From: Brian Lund <bdlund@live.com>
Sent: Friday, November 13, 2015 8:23 PM
To: Lindsey Ozbolt
Subject: Big Creek Trails Rezone (RZ-15-00001) Concerns
Attachments: Rezone (RZ-15-00001) Concerns.pdf

I am writing to voice concerns about the proposed rezone (RZ-15-0001) to facilitate the Big Creek Trails Development. My exact concerns are:

Illustrative Master Plan
Big Creek
 A Planned Unit Development
 Kittitas County, Washington

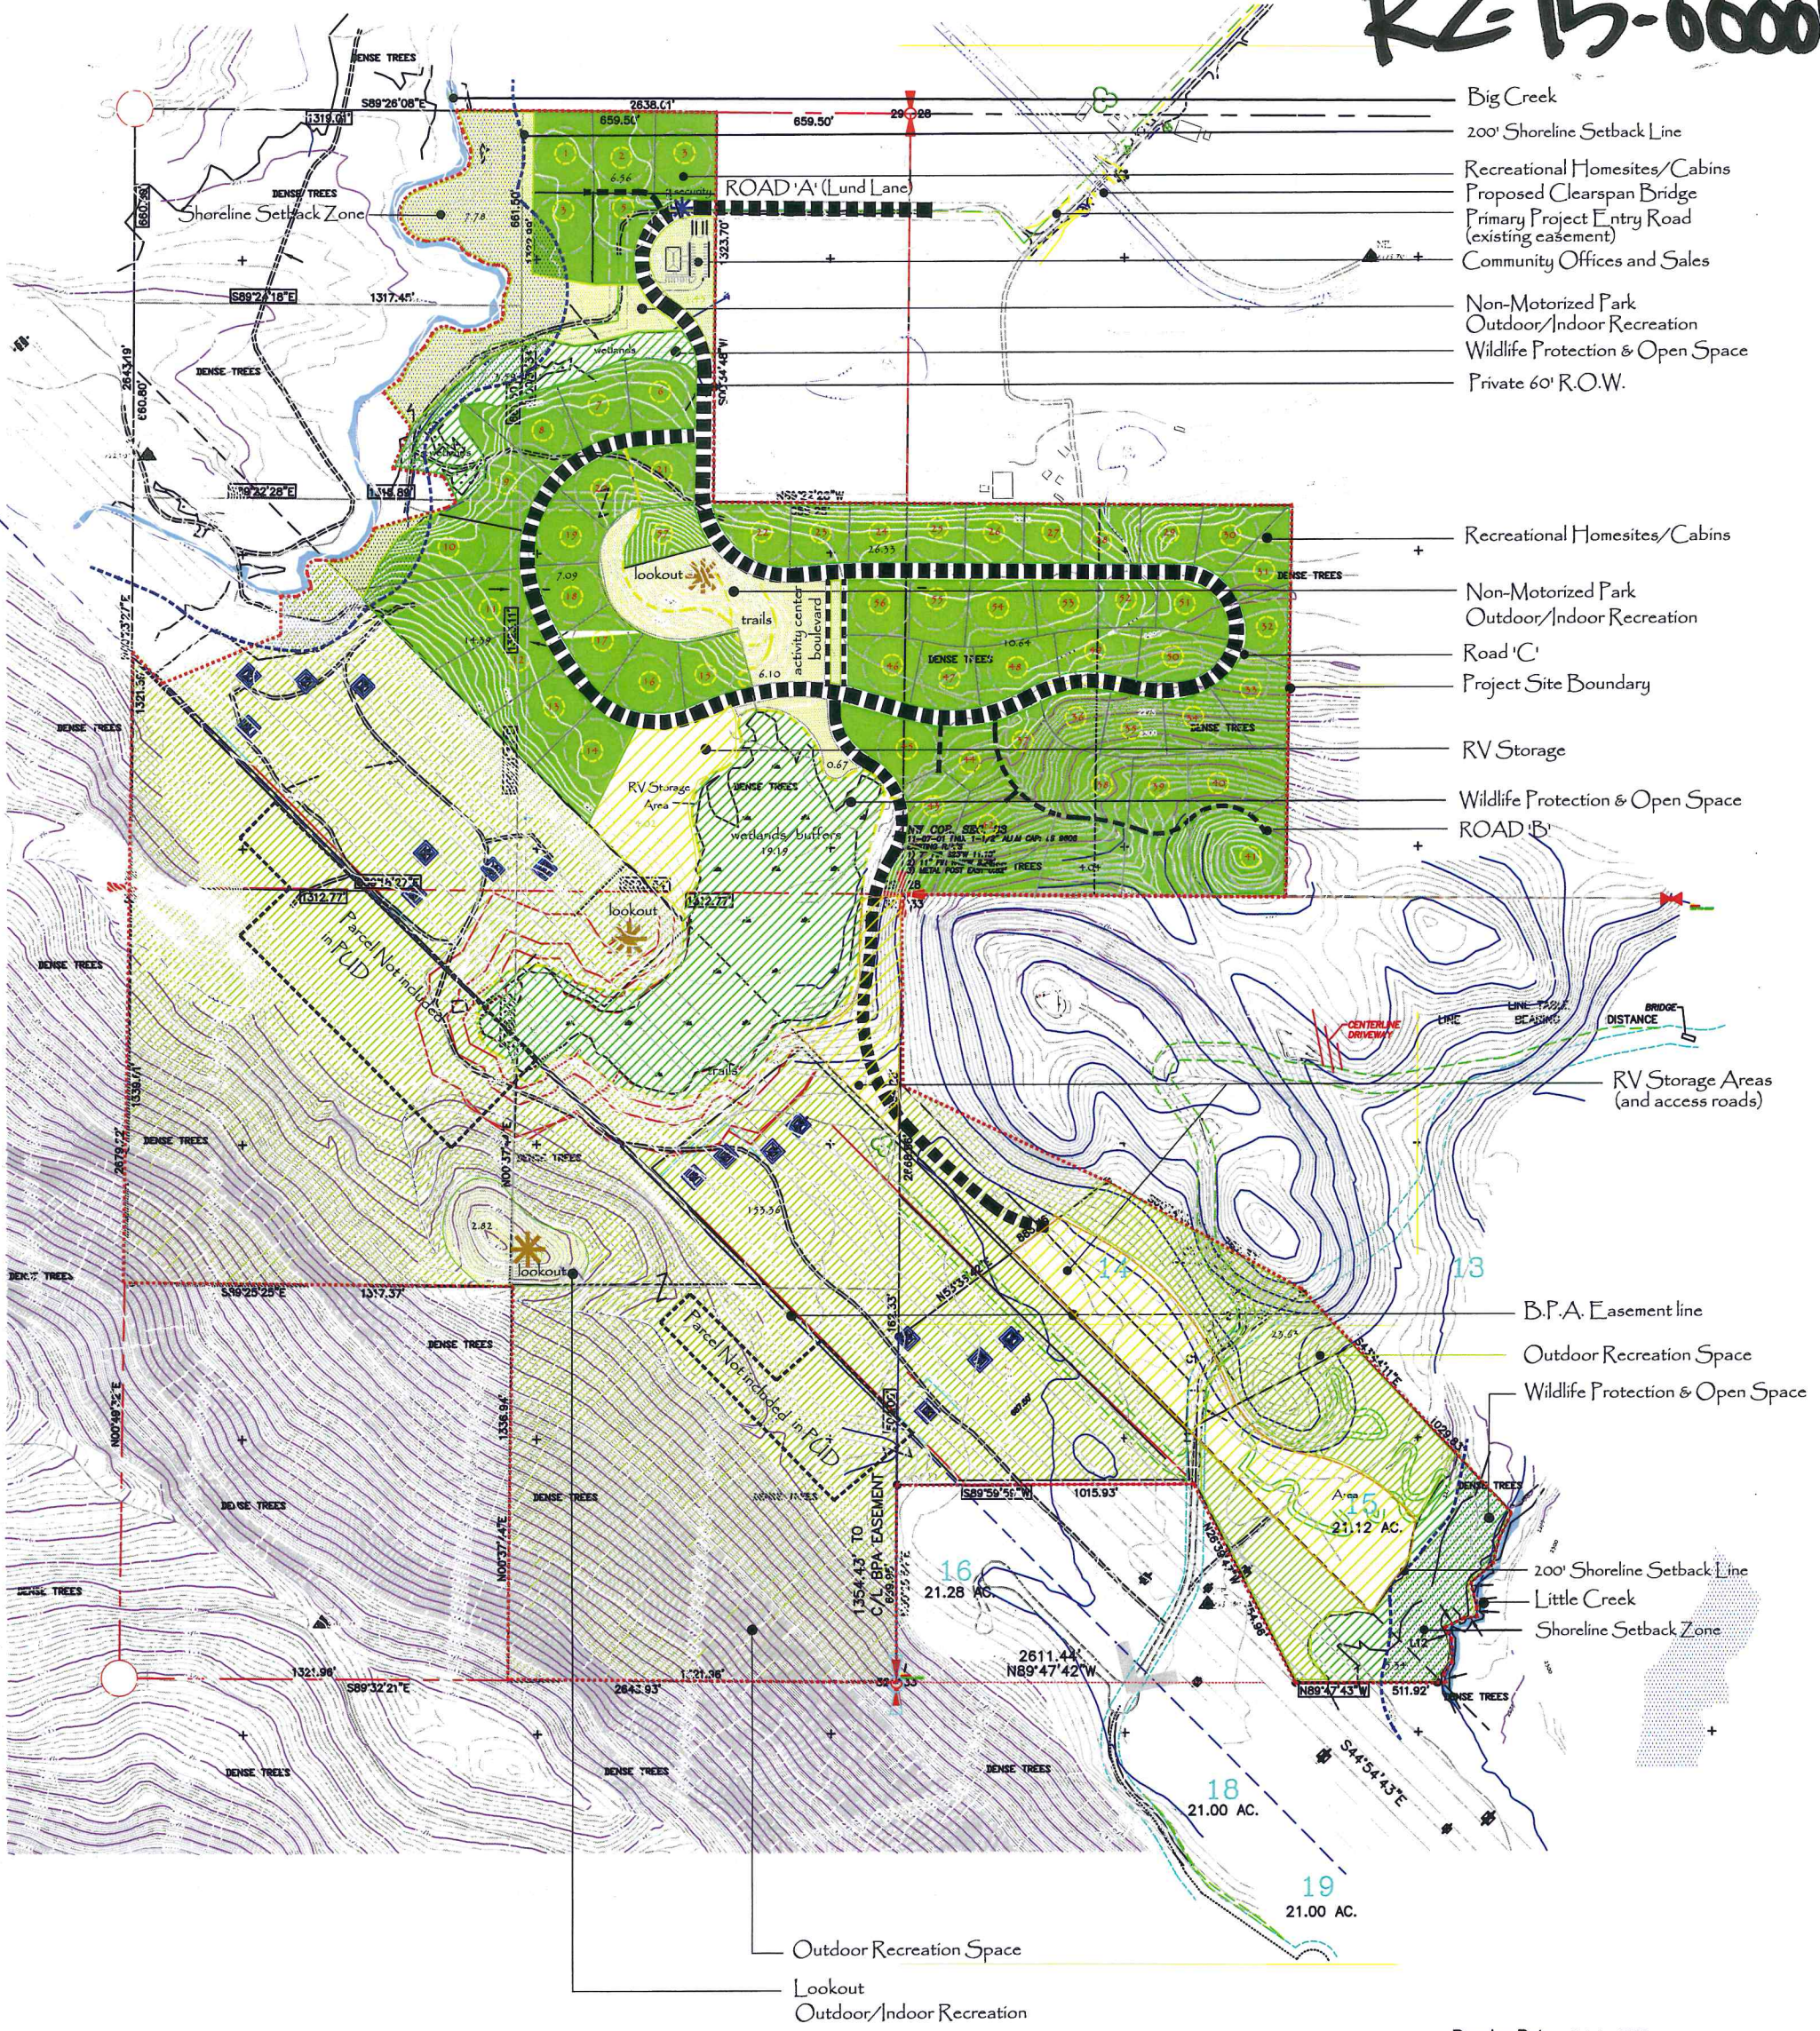
- Will the people living around the development be able to use the trail network?
- There are a lot of wetlands on the property. What is being done to ensure minimal impacts on these sensitive sites?

- Lund Lane is listed as the primary access road. The current easement does not allow for use of Lund Lane by anyone other than people going to and from the Big Creek Trails Development. What is being done to ensure Lund Lane doesn't become the primary access road for adjoining developments?
